Our Ref: 405062_LEO_025

Re: Review of Submissions – Application # 05_0174 Proposed Dredging of Oyster Lease and Operation of Sand Stockpile – Oyster Lease # 80-178 and Lots 59, 101, 123, 124, 125 DP 753207, Lot 12 DP 816473, 2 – 6 Rodmay St, Tuncurry

We refer to the above Environmental Assessment (EA) and to additional public submissions received by the Department during the public exhibition period, in addition to submissions from Great Lakes Council and the Department of Natural Resources (DNR). This report constitutes a response to issues raised in the submissions.

PLAN
 SHOWING OYSTER LEASE DREDGE SITE AND
 SURROUNDS
 WALLIS LAKE, TUNCURRY

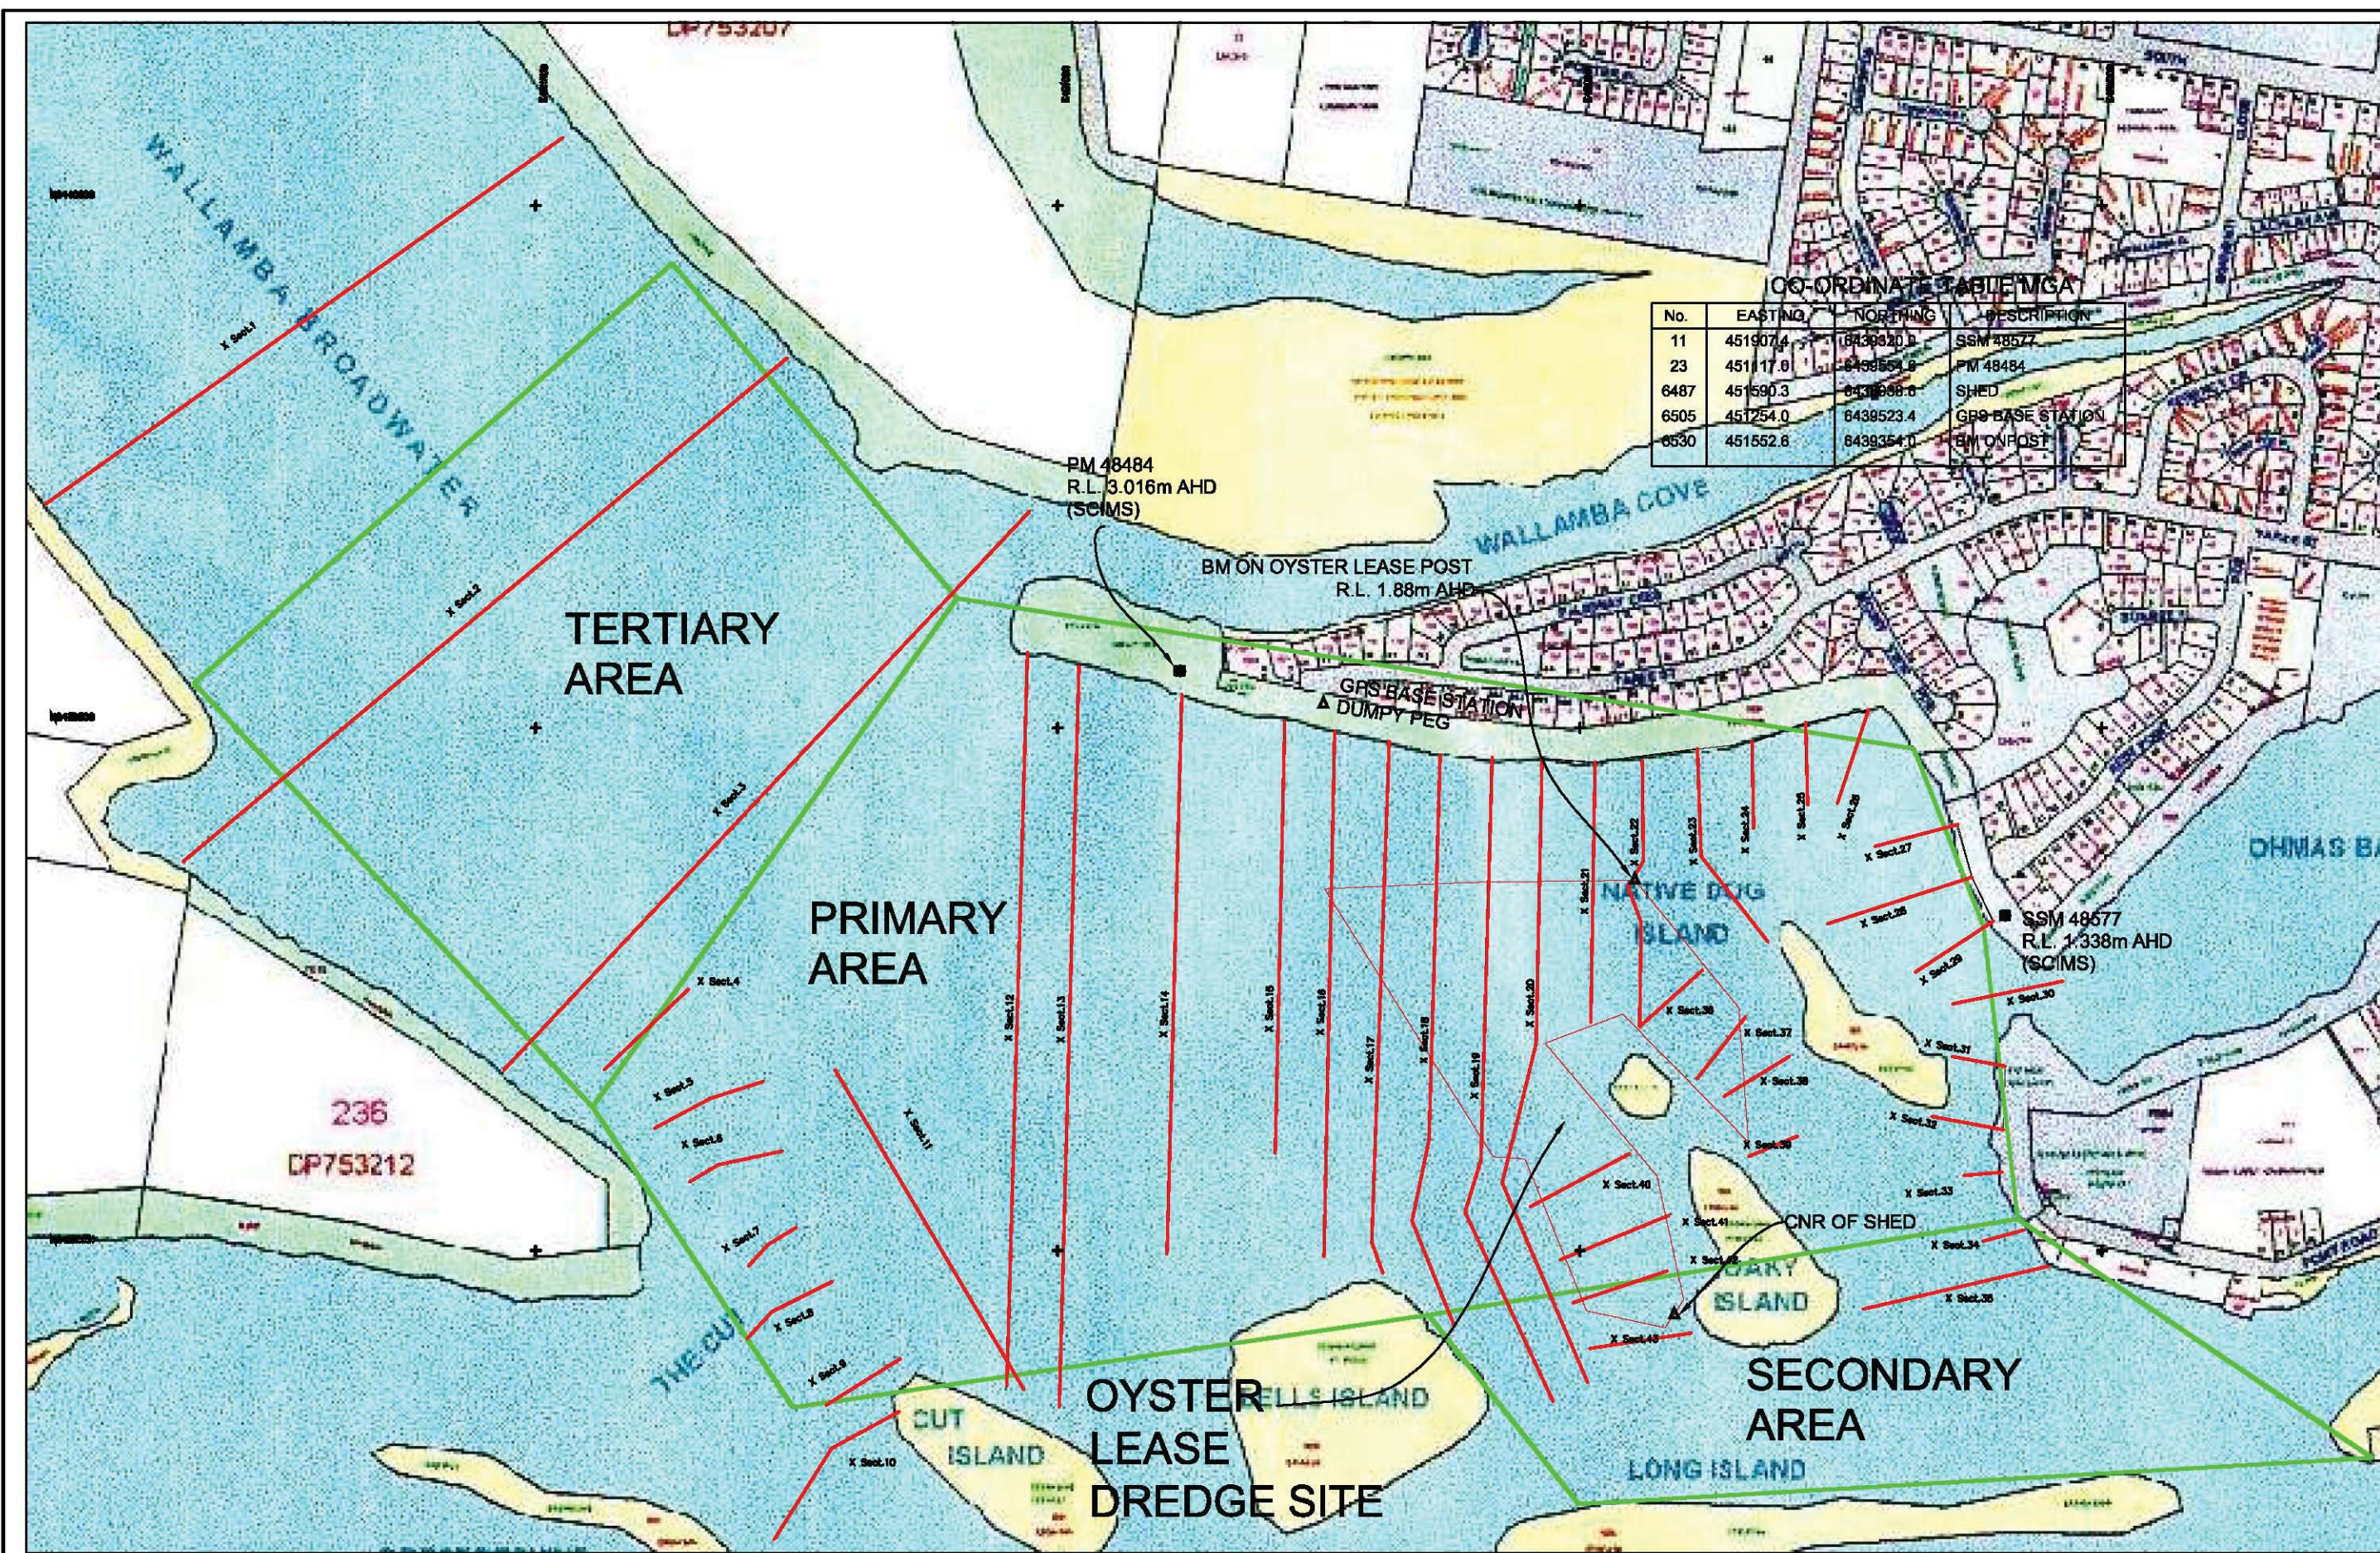
Figures 1.2 and 1.4 of the EA show the location of the oyster lease area for illustration purposes only. The survey plan shown in Appendix B shows the surveyed extents of the area within the lease area proposed for dredging. This outline is shown in Figures 1.2 and 1.4. Figure 1.3 of the EA shows a previous plan of the oyster lease, with a modification made to the lease area. The lease area has been modified (increased) since that time.

Attached is a figure as requested which shows the surveyed extents of the lease area (9.2387 ha) and the area proposed for dredging (8.152 ha) overlaid on the aerial photo of the lease area. A cadastral plan of the lease is also attached. The two areas (1.0867 ha) not included in the proposed dredge area were dredged previously approximately 16 and 25 years ago respectively. These areas have not accreted sediment since being dredged.
